RE: Land adjacent to Woodgate Nurseries Lidsey Road Aldingbourne PO20 3SU

Thank you for your correspondence of the 14th of January 2025, advising me of a planning application for the approval of reserved matters following outline consent AL/129/21/OUT for 95 No residential dwellings with associated parking, landscaping, open space (including play areas), infrastructure and works at the above location, for which you seek advice from a crime prevention viewpoint.

Title: Play and Open Space Proposals Sheet 1

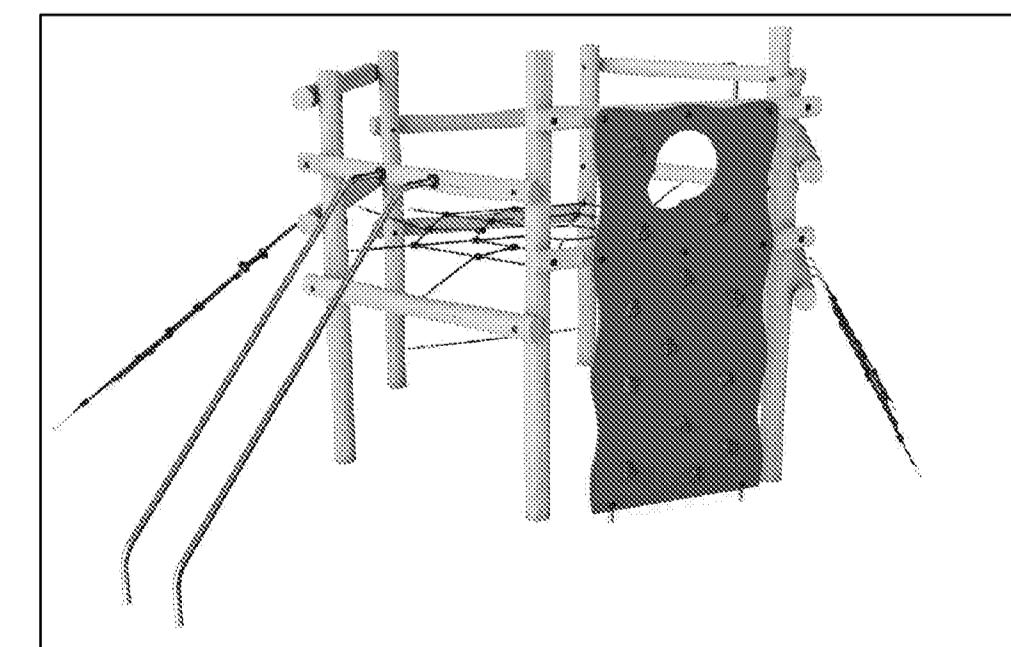
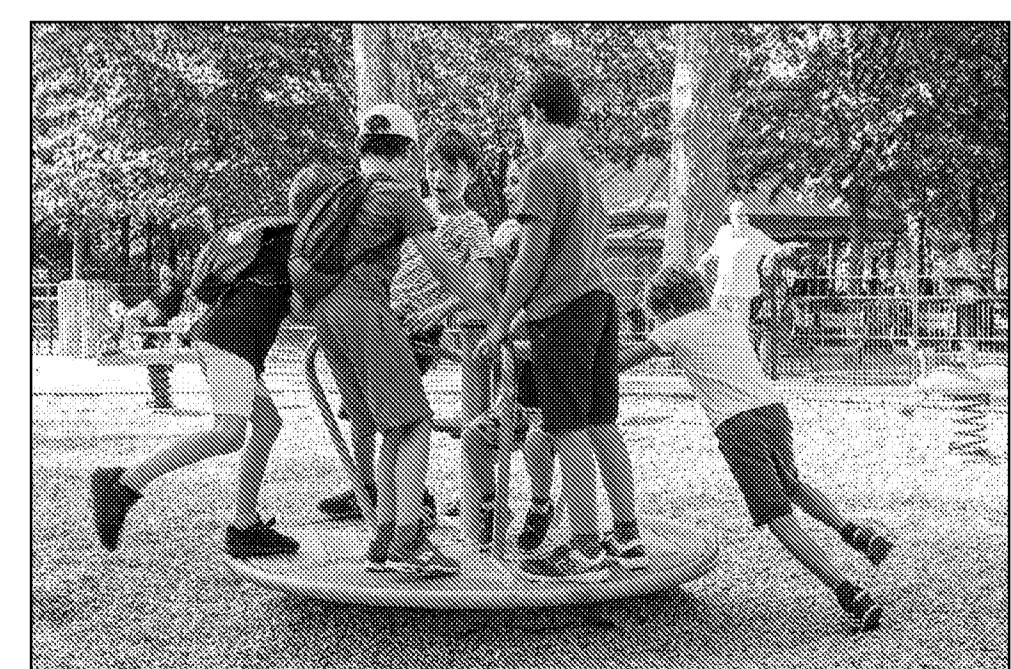
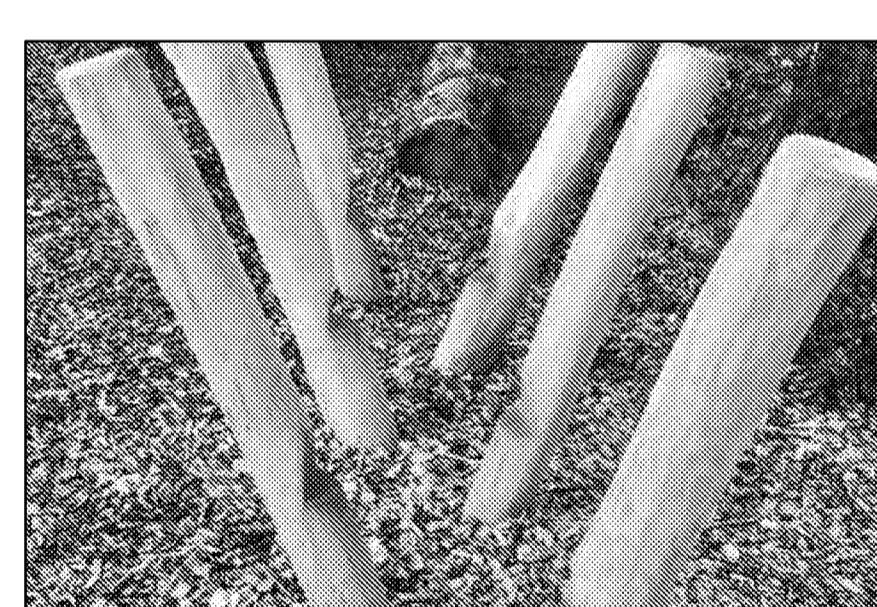
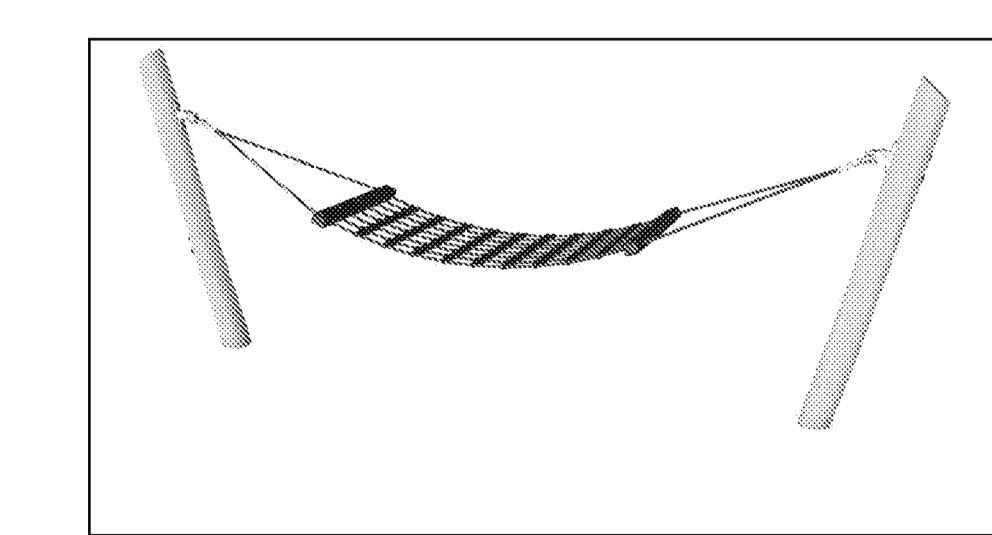
With regards to the proposed LEAP & LAP - areas of play should be situated in an environment that is stimulating and safe for all children, be overlooked with good natural surveillance to ensure the safety of users and the protection of equipment, which can be vulnerable to misuse. They should be designed to allow natural surveillance from nearby dwellings with safe and accessible routes for users to come and go.

Boundaries between public and private space should be clearly defined and open spaces must have features which prevent unauthorised vehicular access. To provide a dog free environment, I would ask that consideration is given to surrounding the play areas with railings and self-closing gates.
